Great North Road Solar & Biodiversity Park – EN010162
Carlton-on-Trent Parish Council – Reference number: [REDACTED]
Deadline 5 response

RE: RE: Water displaced by panels at Carlton-on-Trent

0 0.25 0.5 1 km

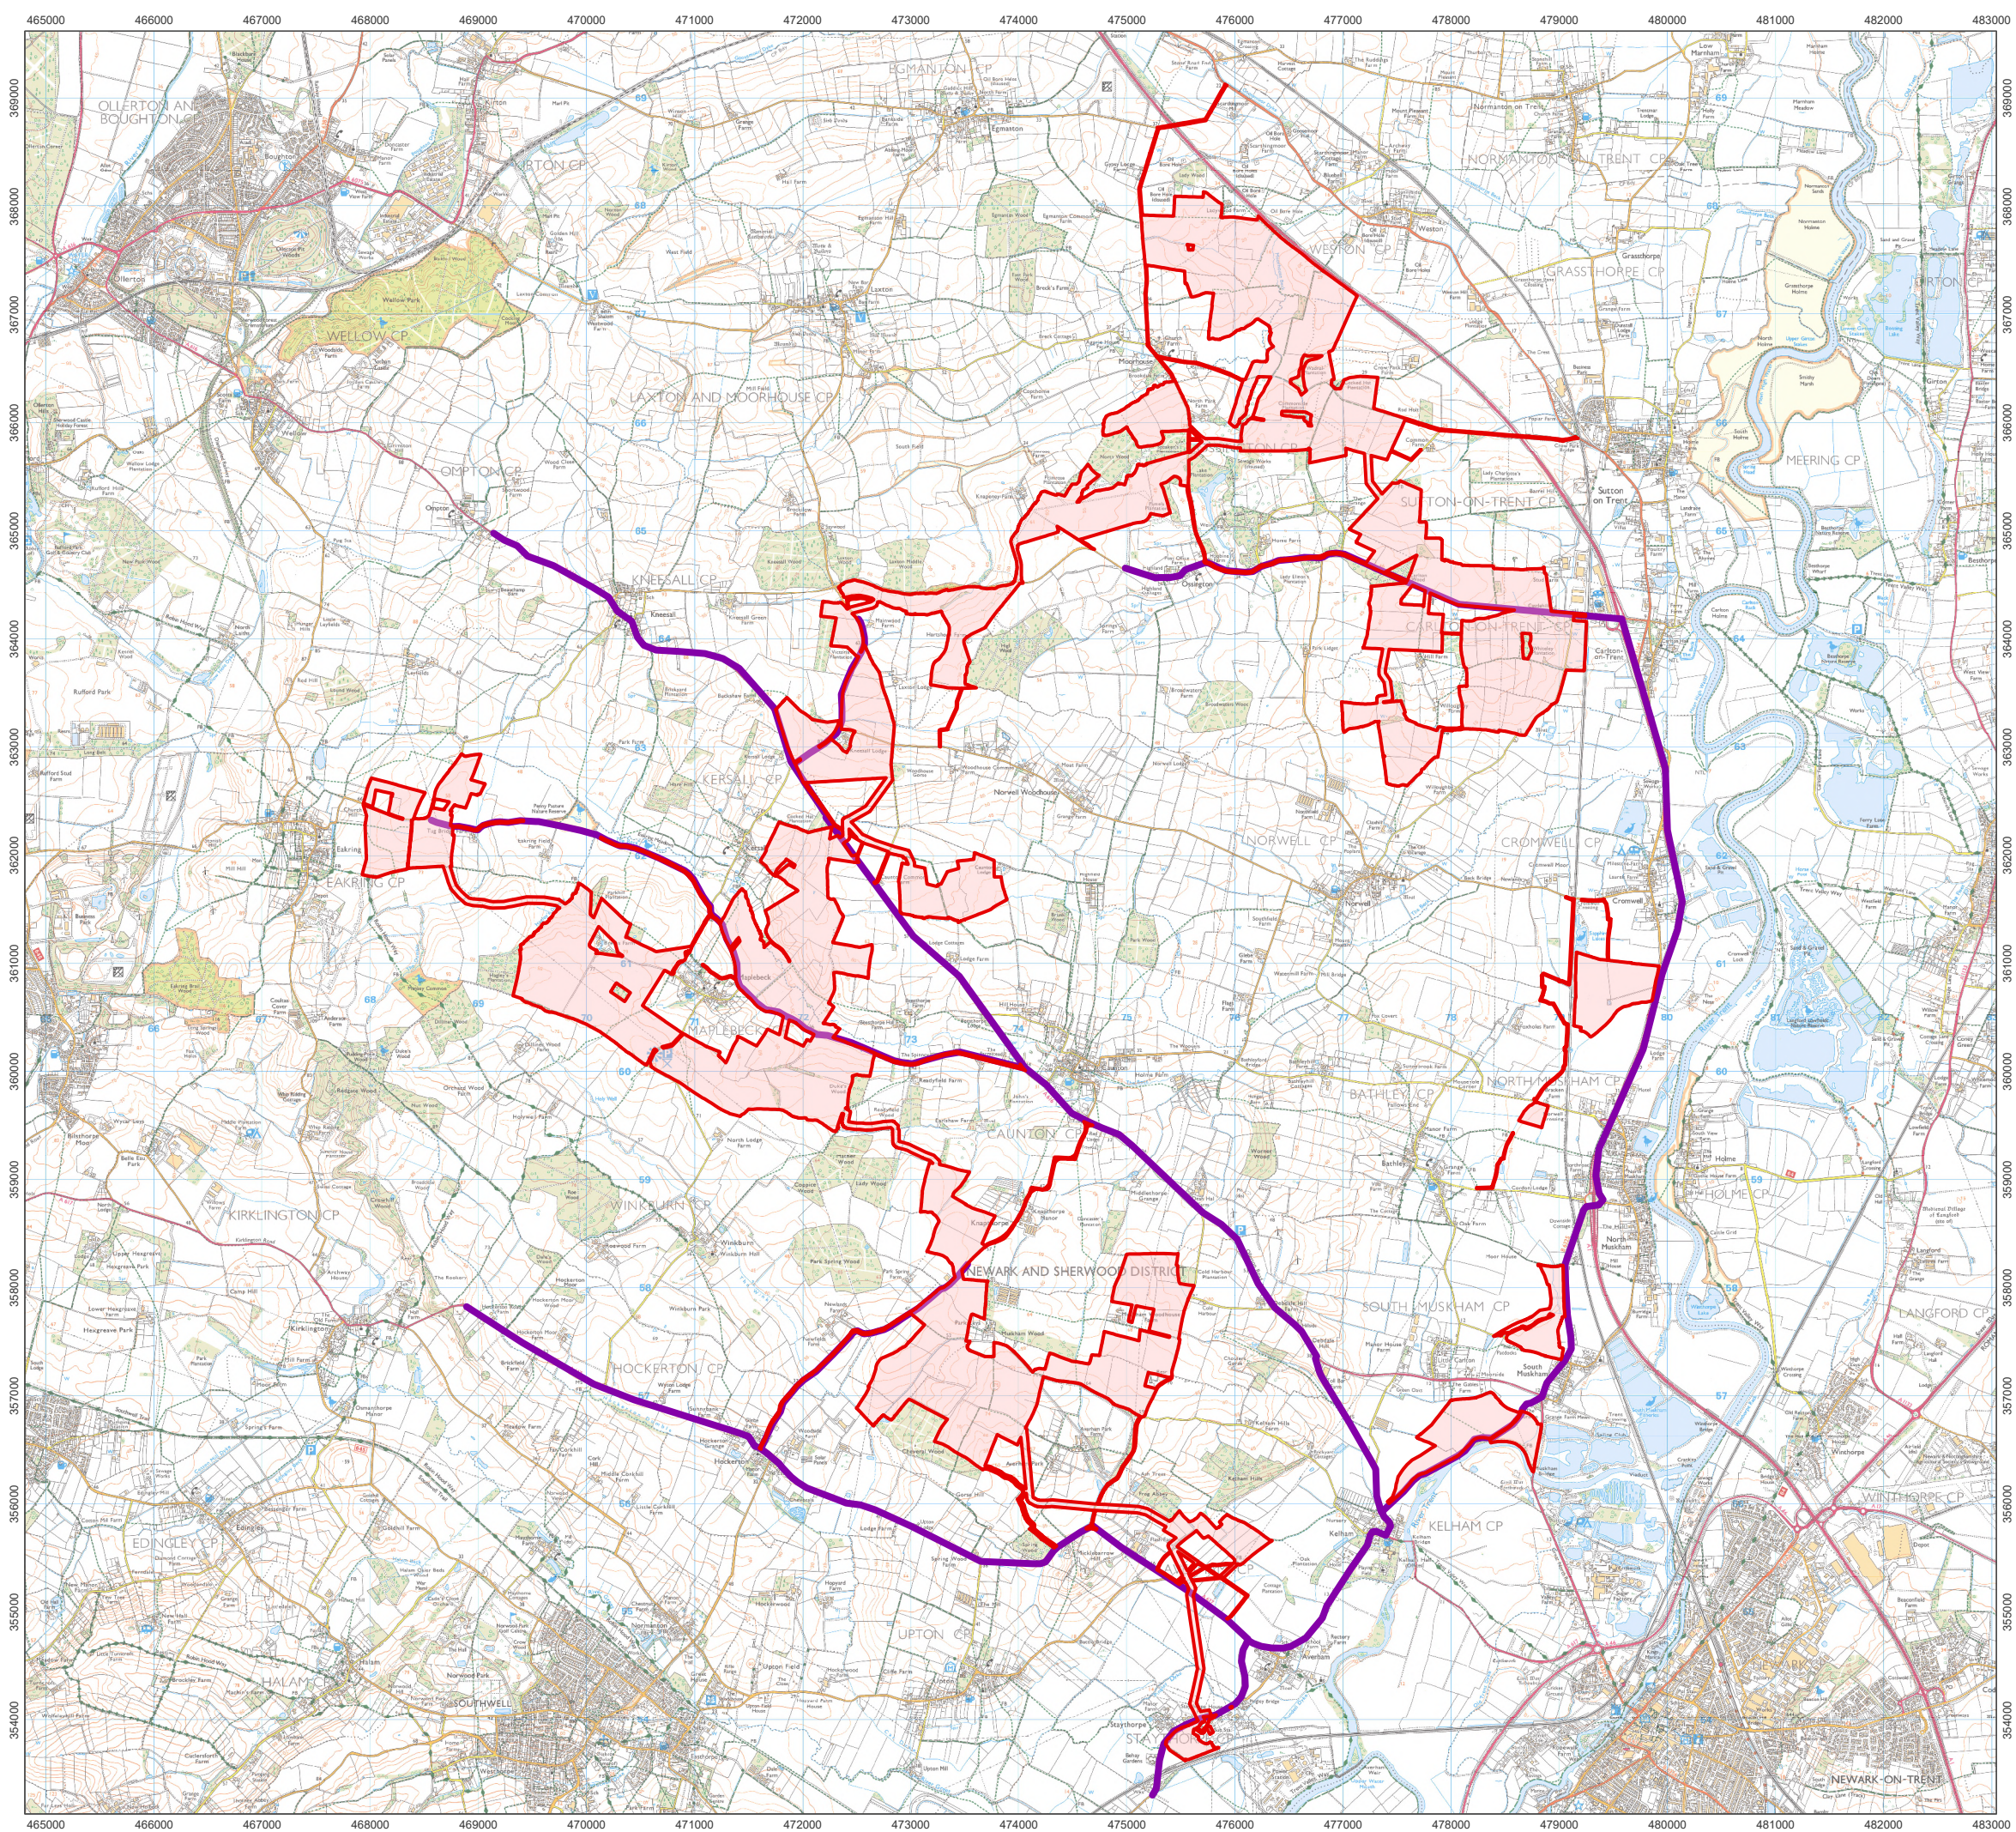
Again, we are focusing on the Carlton-on-Trent area and access to the proposed substation site, apologies I didn't make the clear previously. That said we were able to locate the site access point PA14, thank you.

- Site access arrangements are extensively detailed in ES Technical Appendix A5.2: [Construction Traffic Management Plan](#). An overview of the site access locations can be seen in Figure A5.2.1 presenting the location of the existing (to be upgraded) and new accesses proposed. Access drawings are included within Appendix D of the Transport Assessment [EN010162/APP/6.4.14.1]. These will all be subject to a Road Safety Audit process before construction.
